October 28, 2022

Re: Soper Hill Station – *Technical Review 2*
PA22030

After reviewing the revised application materials, the Planning Division has the following comments:

Elevation West

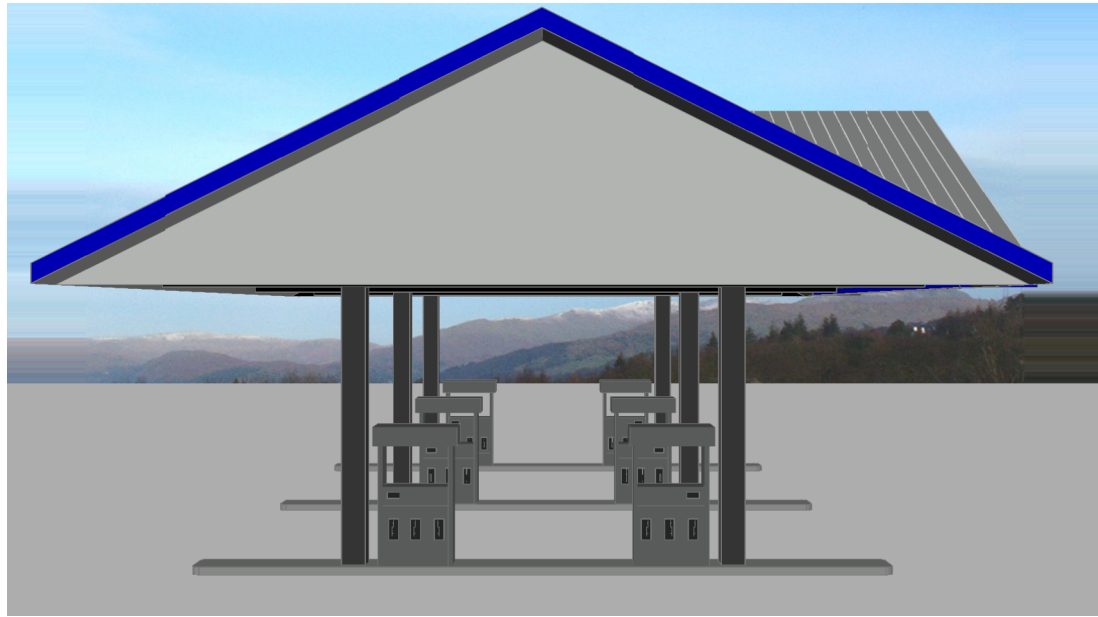
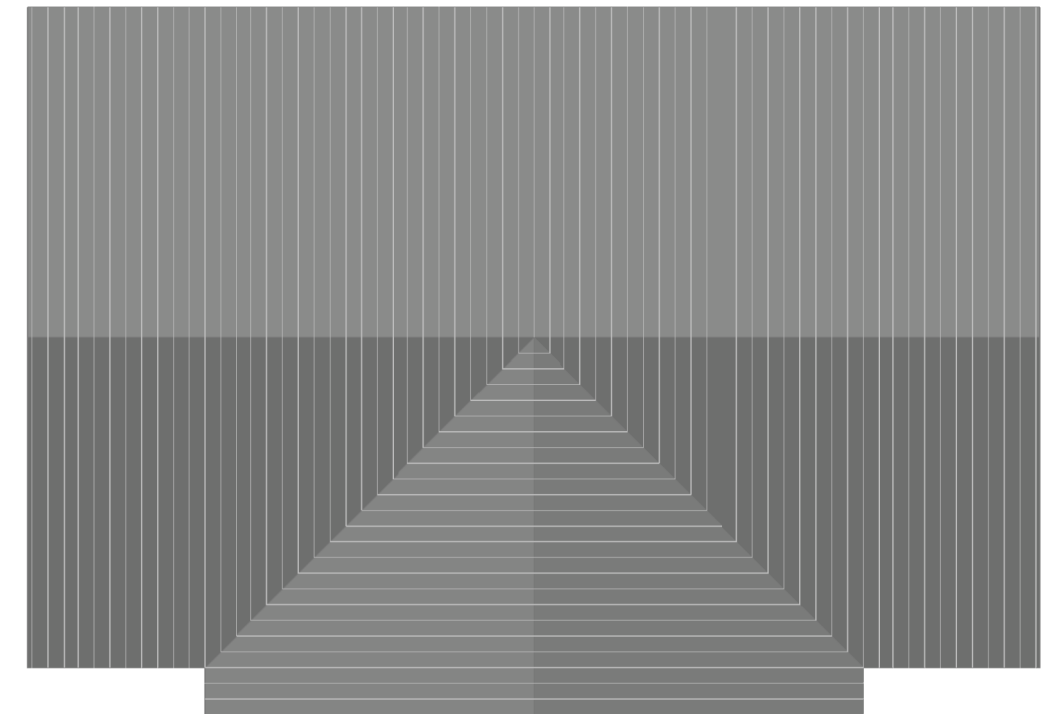
- a. **TR1 Comment:** B.1.2.b. requires the ground floor façade between 2 and 8 feet above the ground shall contain a minimum of 75% transparent window area. The north façade does not comply with this requirement.

TR2 Comment: In review of store elevations provided it does not appear the revisions comply with B.1.2.b, as noted above.

- b. **TR1 Comment:** All elevations shall be amended to comply with the blank wall treatment standards outlined in E.3.4. Changing of the CMU wall color does not meet the blank wall standards.

TR2 Comment: The north east and west elevation does not appear to comply the provisions outlined in E.3.4. Additionally, the landscape plans should be amended to include what is proposed to be planted on the south elevation trellis.

Applicant's Response: Plans have been revised accordingly.

Applicant's Response: Plans have been revised accordingly.

DRAWING TITLE:
LANDSCAPE PLAN

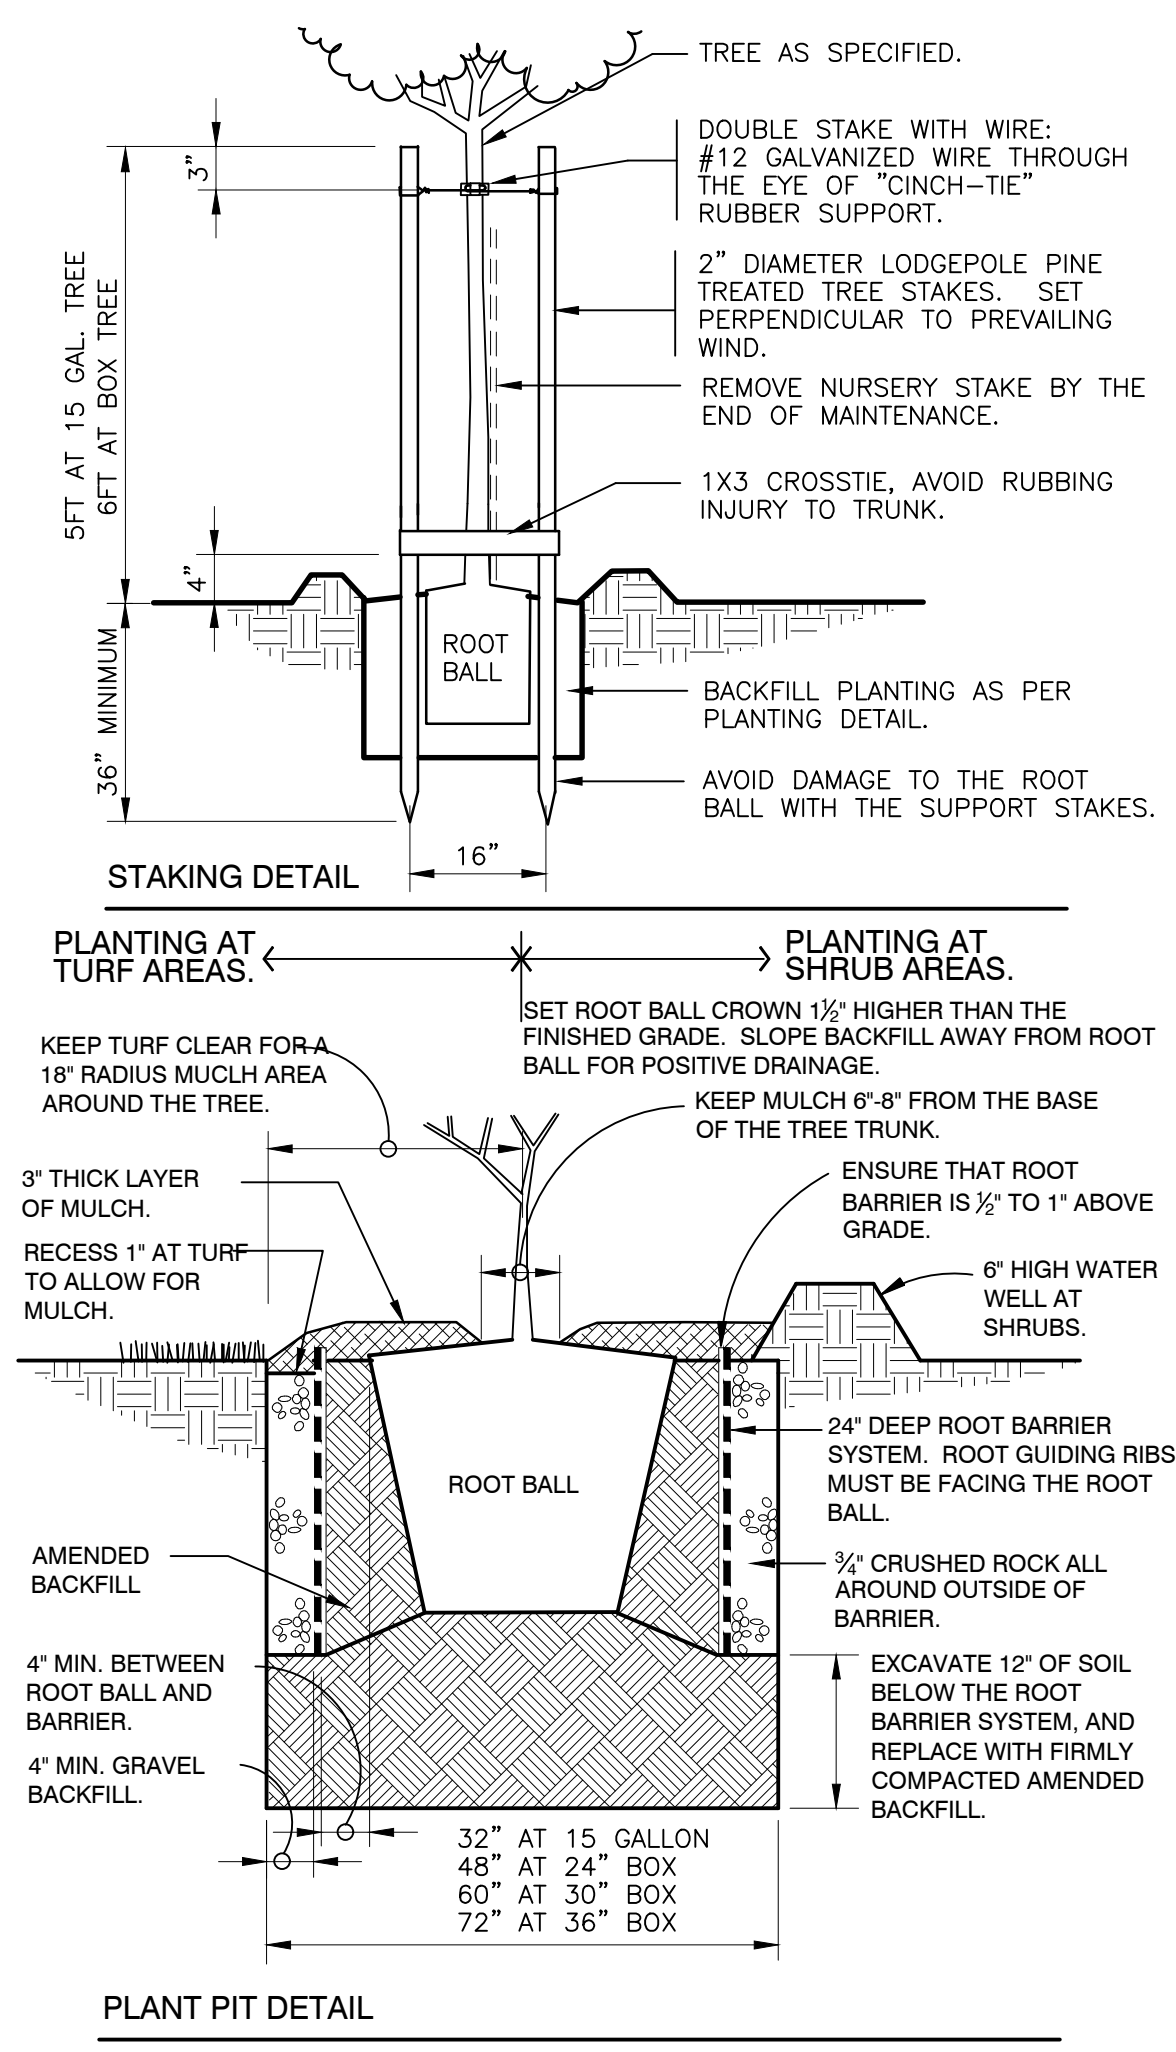
- a. **TR1 Comment:** F.1.1 requires a 30' landscaping setback from Soper Hill Road and a 20' setback is required from Road A when a parking areas and drive aisles are located adjacent to these roadways.

TR2 Comment: See comment 2.c. above.

Applicant's Response: Per our previous conversation a Type L3 10-foot buffer has been provided along both Drive Aisle A and Soper Hill Rd. In addition, landscaping will be provided in the 5-foot planter strips between Soper Hill Rd and Drive Aisle A.

**SP-01**  
 SHEET 1 OF 2

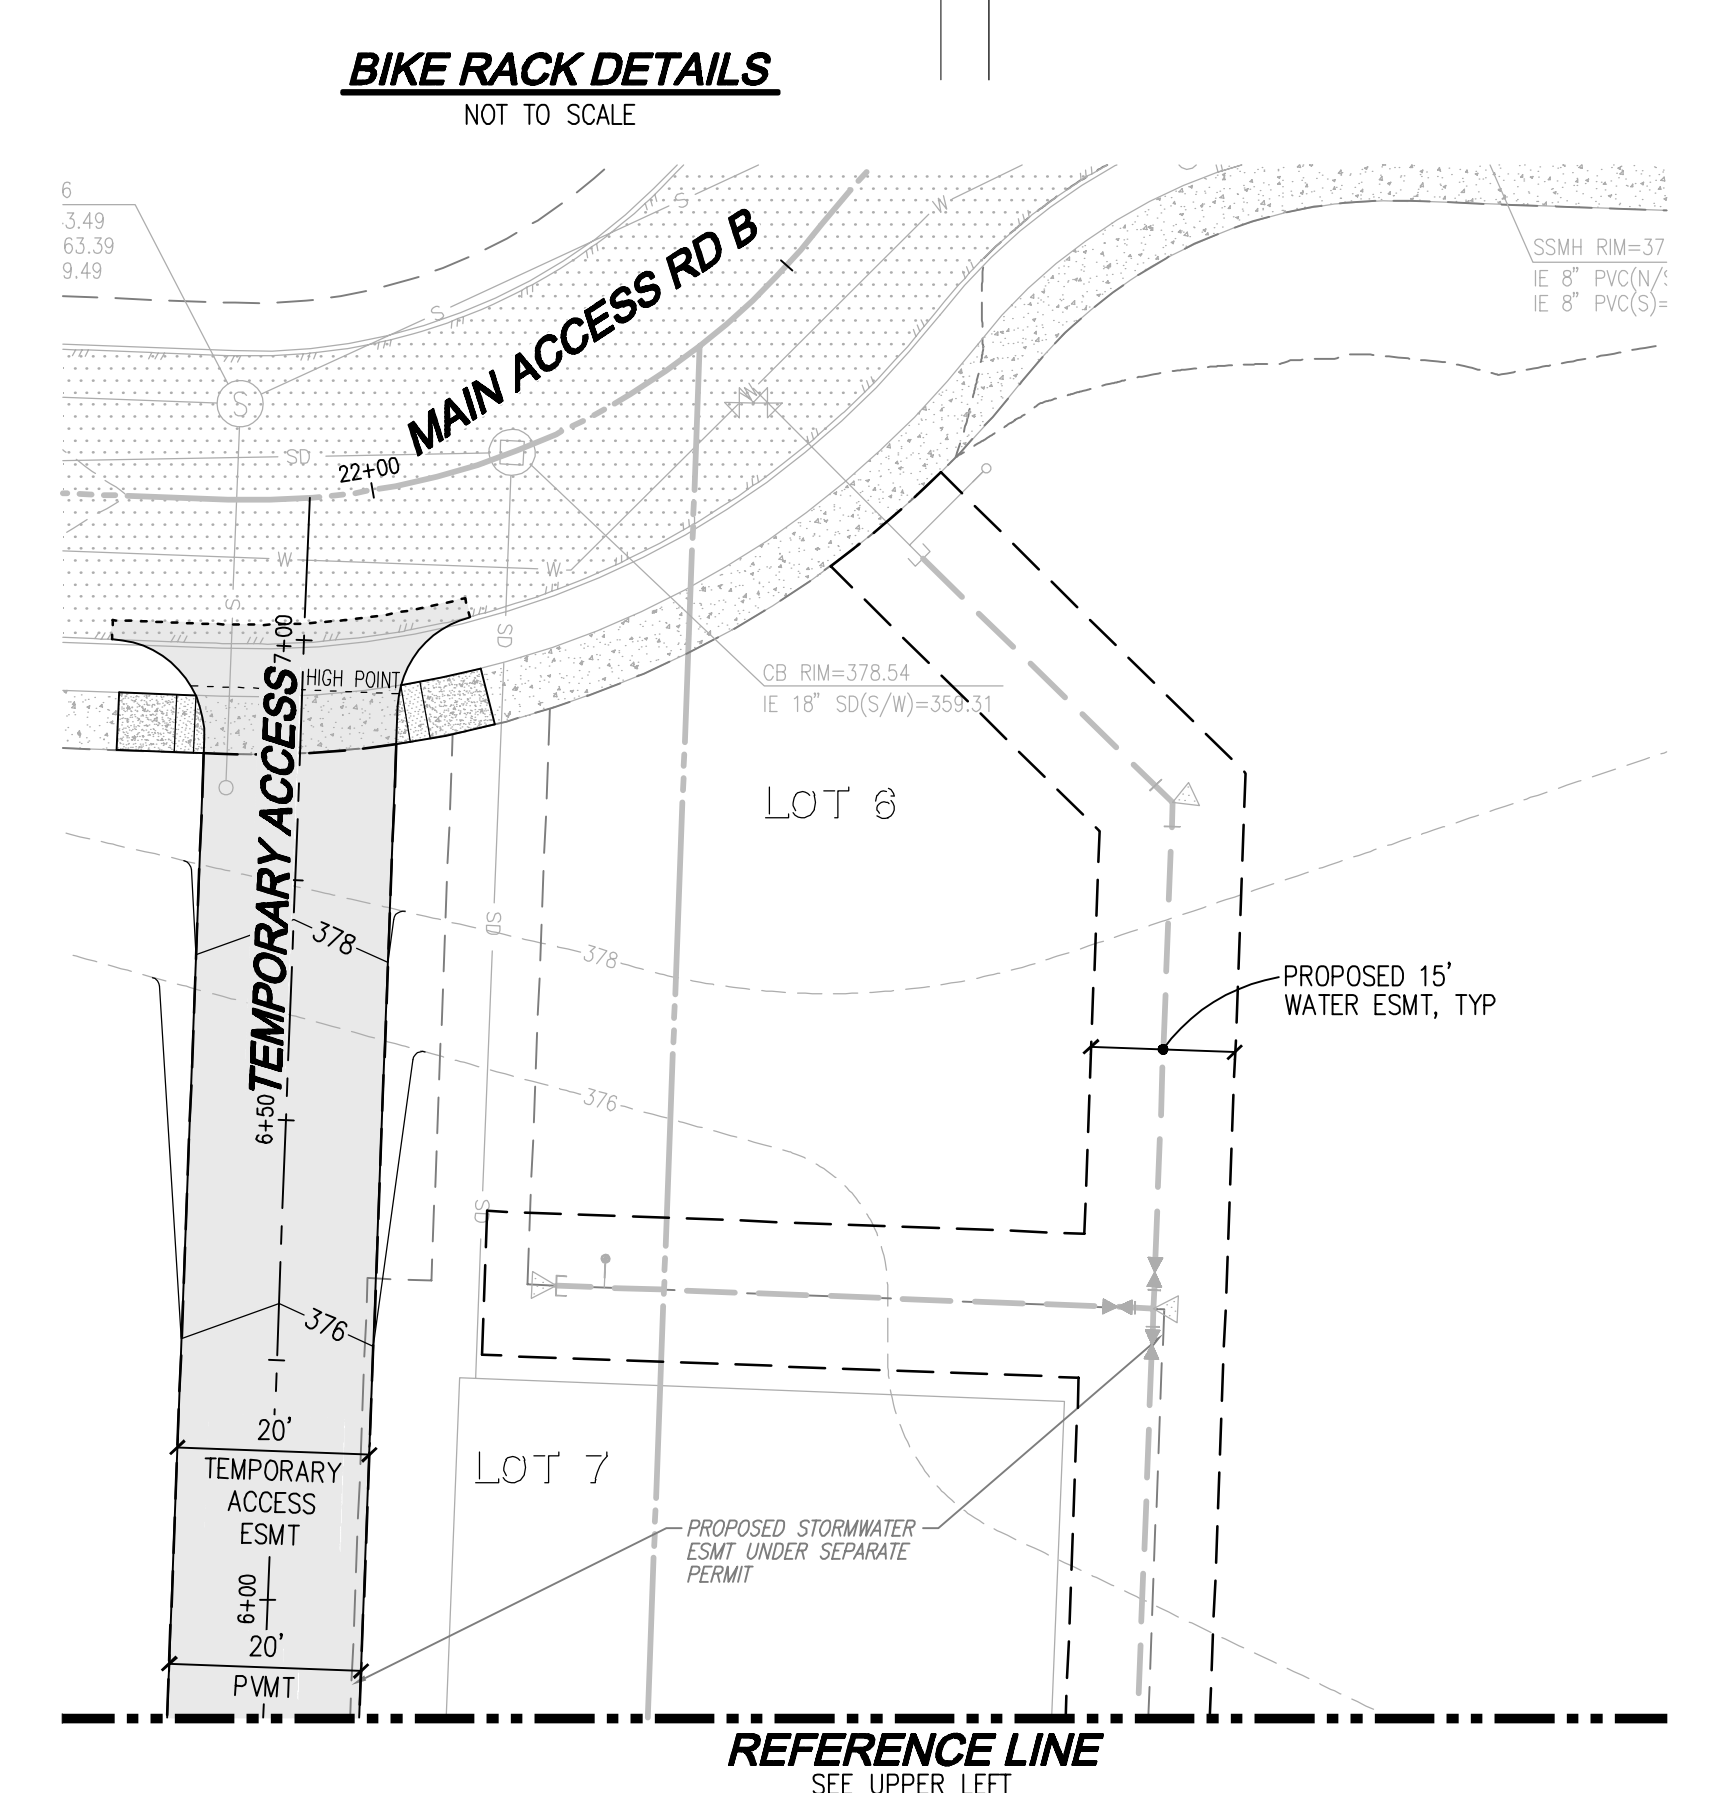
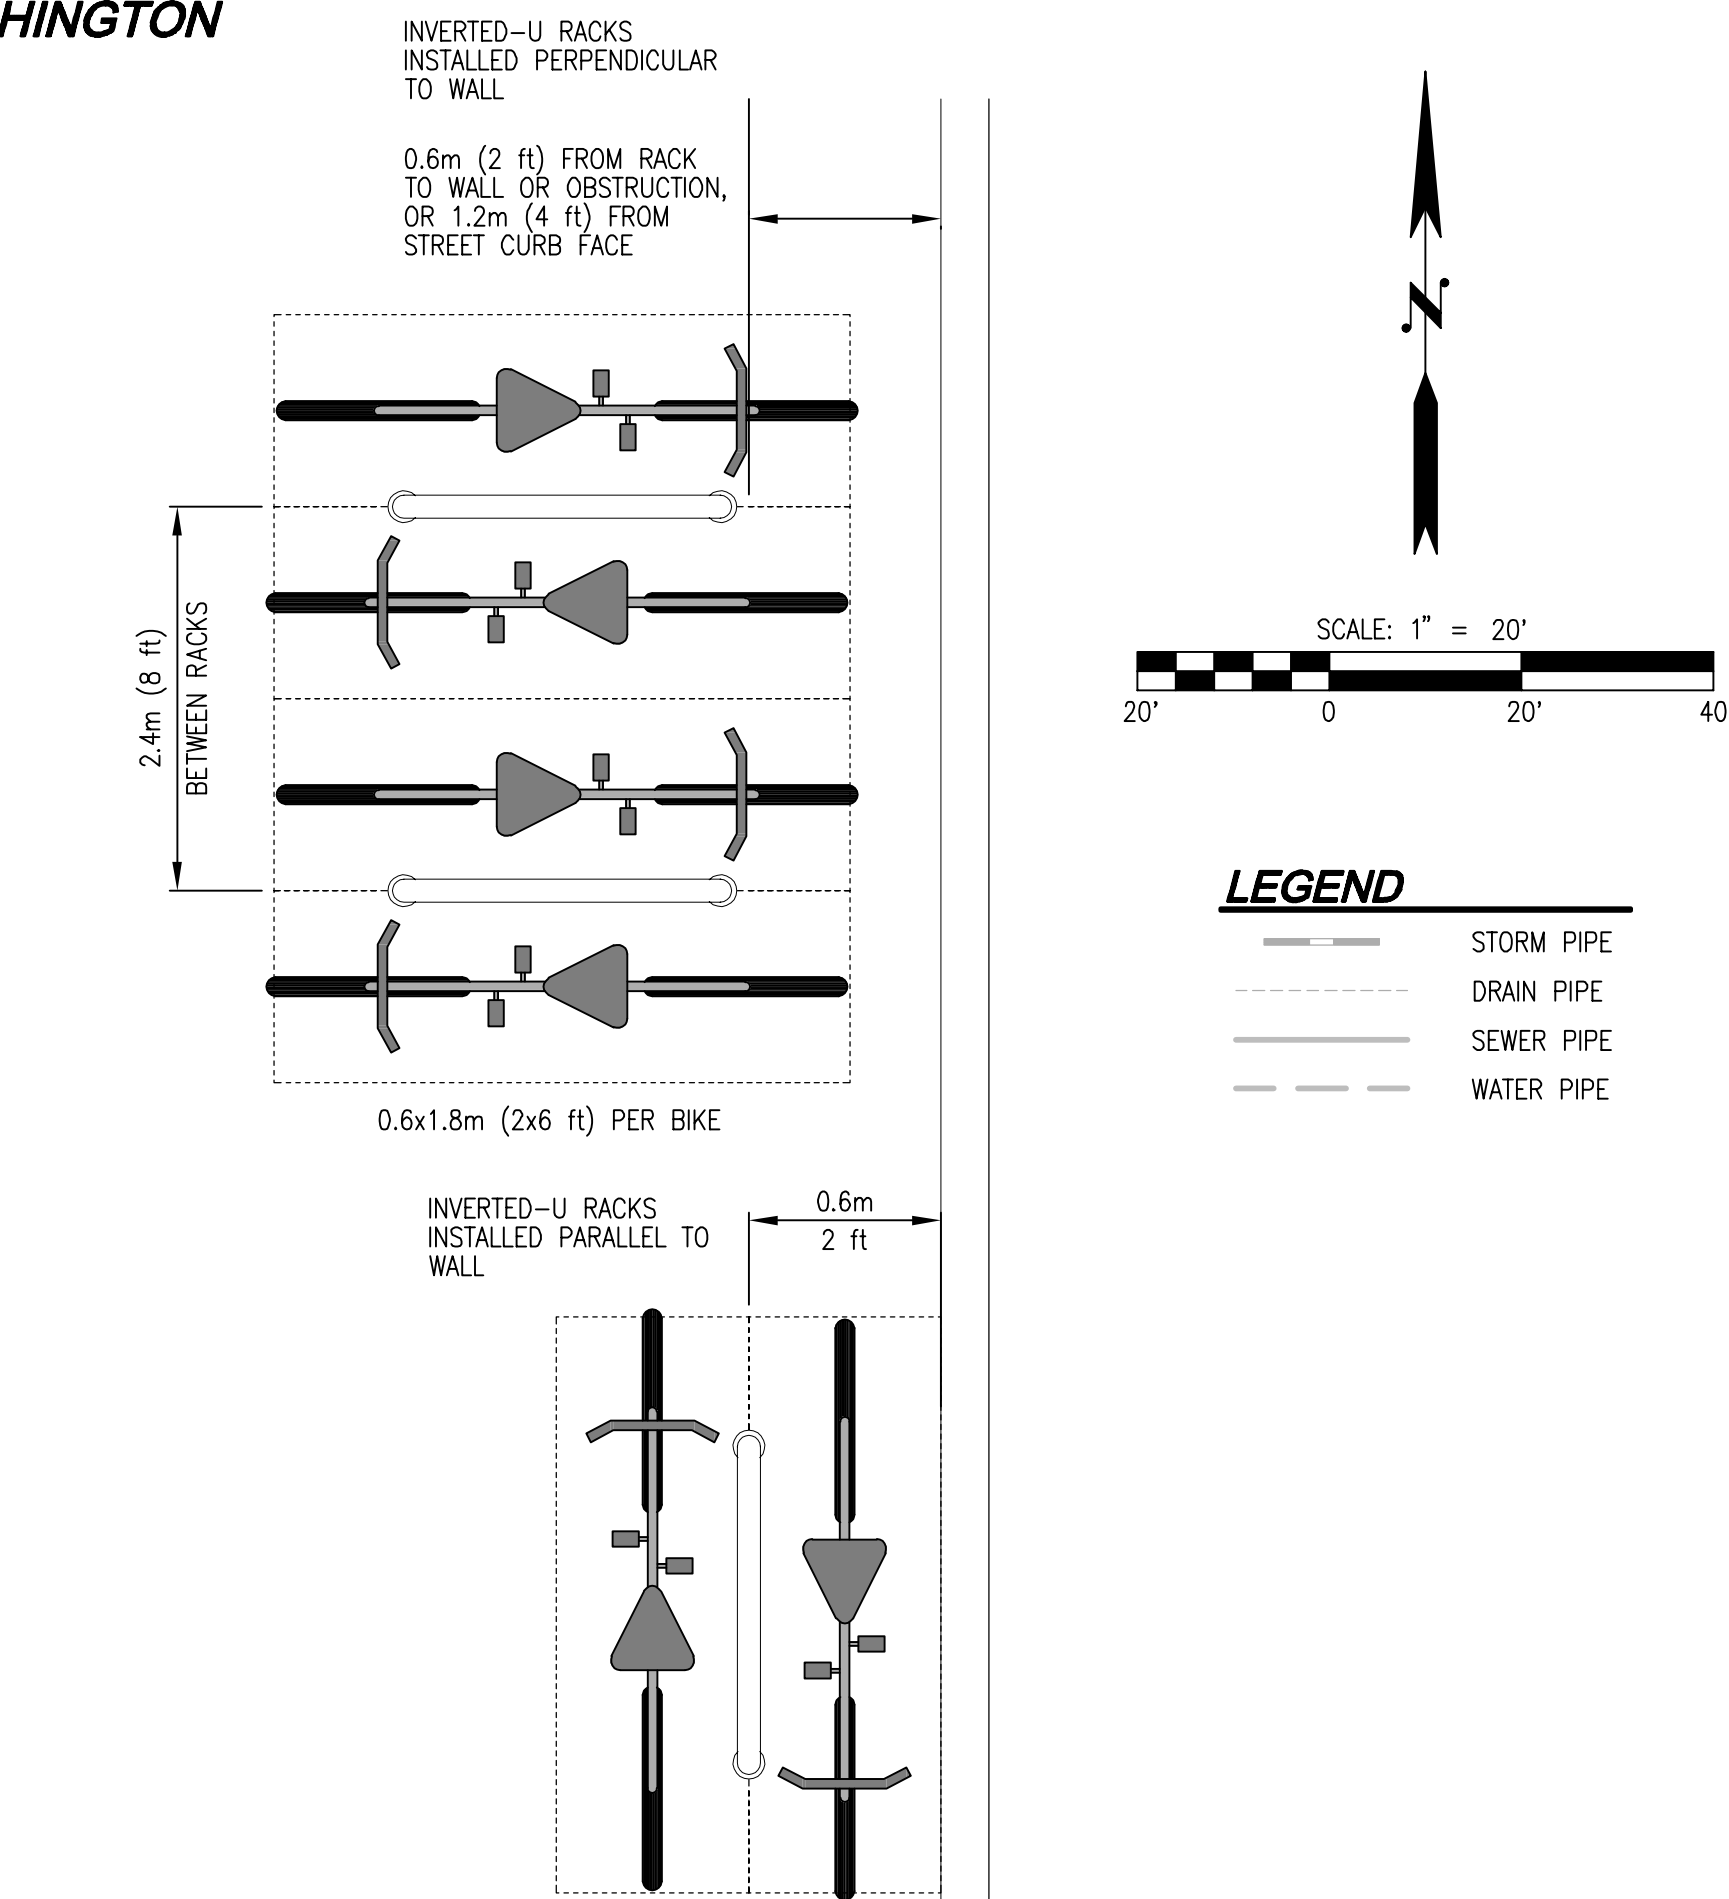
- a. **TR1 Comment:** Provide a pedestrian connection from Lot 2 across the Main Access Drive to Lot 3. Consider potential development of Lots 3 & 4 for location of pedestrian connection.

TR2 Comment: A pre-application has been submitted for Tommy’s Express Carwash for Lot 3. If developed with a carwash undoubtedly passengers of patrons are vacuuming there vehicles will ultimately walk over to the proposed

convenience store. This connection should be coordinated between the two uses and a condition will be added to the preliminary site plan approval.

- b. **TR1 Comment:** B.4.1.a. requires a side and rear setback of 15'. It appears the building is only setback 10' along the south property line.

TR2 Comment: Building is only setback 12' 6" from south property line. Additionally, please remove the "10' BSBL" reference along Soper Hill Road.

- c. **TR1 Comment:** F.1.1 requires a 30' landscaping setback from Soper Hill Road and a 20' setback is required from Road A when a parking areas and drive aisles are located adjacent to these roadways. The *Director* may approve and condition reduced planter widths provided the design meets the intent of the standards and guidelines. For example, reduced widths may be allowed provided the landscaped area is supplemented with architectural features that help to define the street edge and maintain visual continuity along the street. Examples could include a decorative low wall made of stone or masonry that is used in conjunction with landscaping, and/or use of a landscaped trellis or architectural columns. For each method, it is important to maintain visibility at eye level (between 3 and 8 feet above the ground) between the street into the parking lot for safety.

TR2 Comment: I do recall discussing a reduced landscape buffer, however, simply providing a 10' L3 buffer was not what I recall. In order for a reduced landscape buffer to be approved by the director the landscaped area shall be supplemented with architectural features that help to define the street edge and maintain visual continuity along the street. Examples could include a decorative low wall made of stone or masonry that is used in conjunction with landscaping, and/or use of a landscaped trellis or architectural columns. Please provide a proposal for Director consideration.

Applicant’s Response: Pedestrian connection from site to sidewalk along Main Access Drive A has been added. Connection to Lot 2 to be determined when Lot 2 development occurs. No sidewalks are currently proposed on Lot 2, as a site plan has not been approved so no reason to provide a midblock crossing of the access drive at this time.

Applicant's Response: Building has been adjusted to provide appropriate setbacks from property lines and overhead wire.

Applicant's Response: Per our previous conversation a Type L3 10-foot buffer has been provided along both Drive Aisle A and Soper Hill Rd. In addition, landscaping will be provided in the 5-foot planter strips between Soper Hill Rd and Drive Aisle A.
